From: Hannah Kersley
Sent: 23 July 2025 12:22
To: Planning.Responses
Subject: FW: BR/64/25/PL
Attachments: Drawing 5A - Proposed Floor Plan.pdf

I'm contacting in regard to the application at 3 and 4 Queens Square (BN/64/25/PL). We are currently in the process of reviewing the application, and as an objection has been received from Bognor Regis Town Council, are evaluating whether we are in a position to be able to recommend approval, and take this to be determined at the Planning Committee.

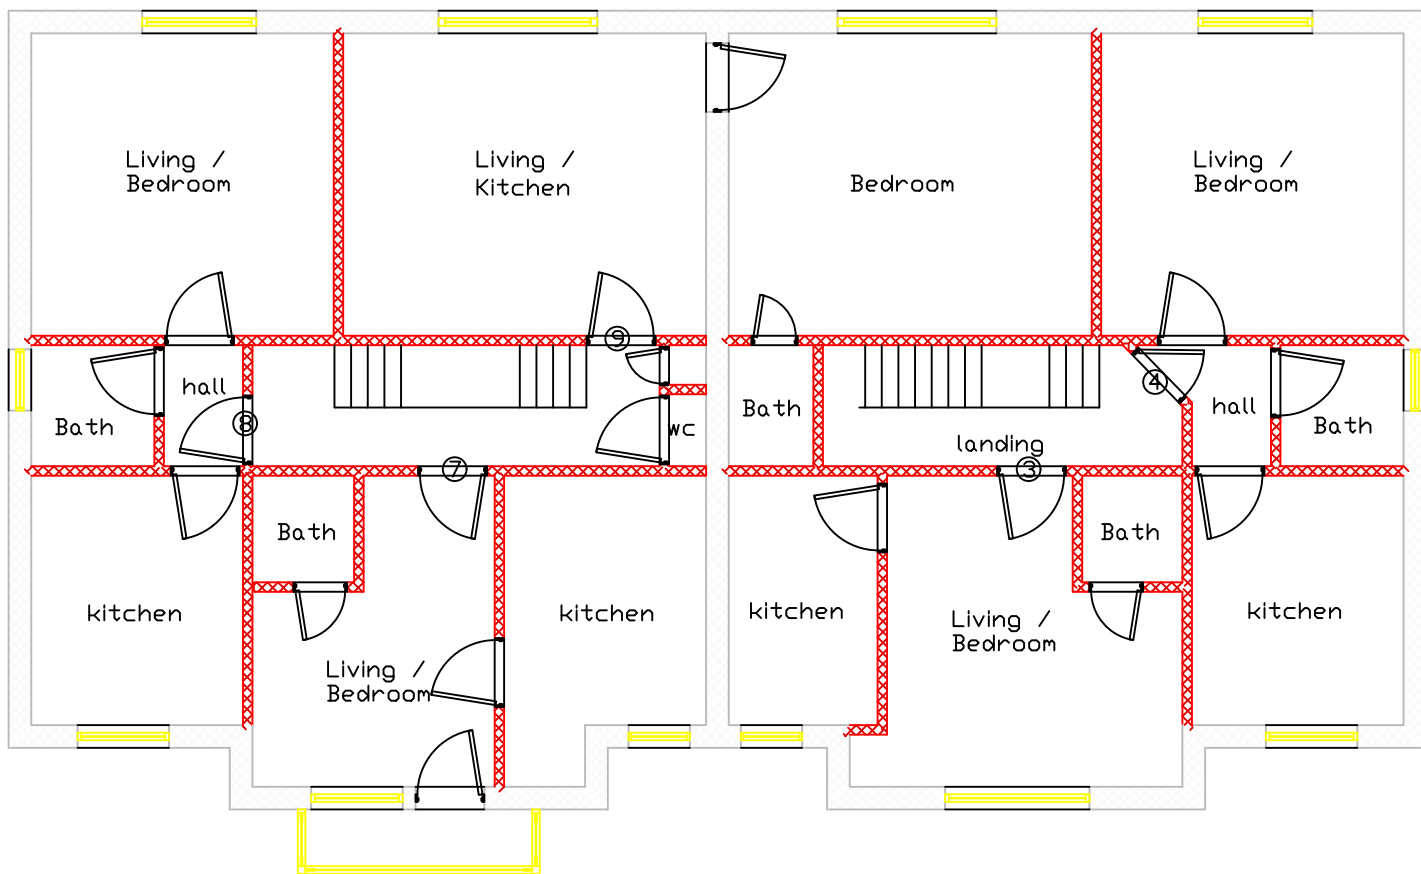
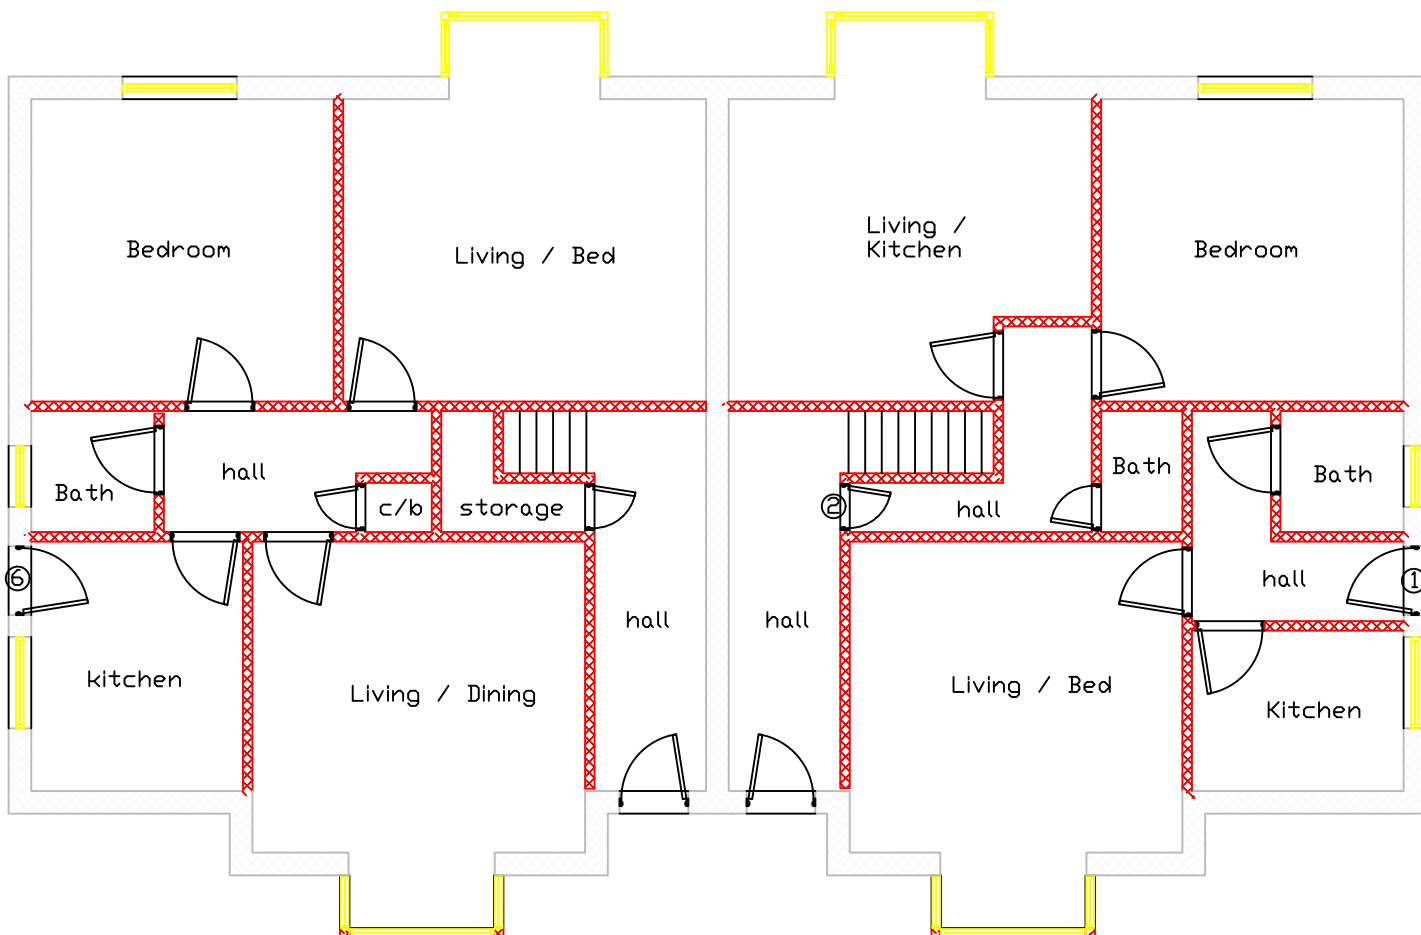
Whilst we are not opposed to the principle of the change, we have identified there a 5 units which do fall short of the minimum required internal area for 1 bed flats under the NDSS ([Technical housing standards – nationally described space standard - GOV.UK](https://www.gov.uk/technical-housing-standards)). We use the NDSS to assess proposals against Policy D DM2 of the Arun Local Plan, and ensure that the internal space being provided to occupiers is sufficient to provide a good quality living environment, and meets their needs. In this case, the following flats fall short of the minimum 37sqm set by the NDSS:

- Flat 1 = 34sqm
- Flat 3 = 23sqm
- Flat 4 = 30sqm
- Flat 7 = 23sqm
- Flat 8 = 30sqm

us to assess the proposal against current adopted policy and standards. It is likely we can take a pragmatic stance for flats 1, 4 and 8; however we do have significant concerns regarding the footprints for flats 3 and 7, and do feel that these areas are too small for us to consider them acceptable as residential units. It would not be possible for us to enforce that these two flats are only occupied by single residents to ensure their amenity is protected, and therefore we do not feel this is something we can overcome through a condition. I'm afraid it is unlikely that we will be able to support this scheme as it is at present given there is such a shortfall between the required 37sqm and proposed 23sqm.

As a result, we were wondering if there was any possibility that flats 3 and 7 could be combined to create a single flat? This would create a floor area of approximately 46sqm, which would sufficiently exceed the minimum 37sqm, and comply with policy D DM2.

In order to ensure officer support, we reluctantly agree to your request and therefore please find attached Drawing 5A which merges units 3 and 7.
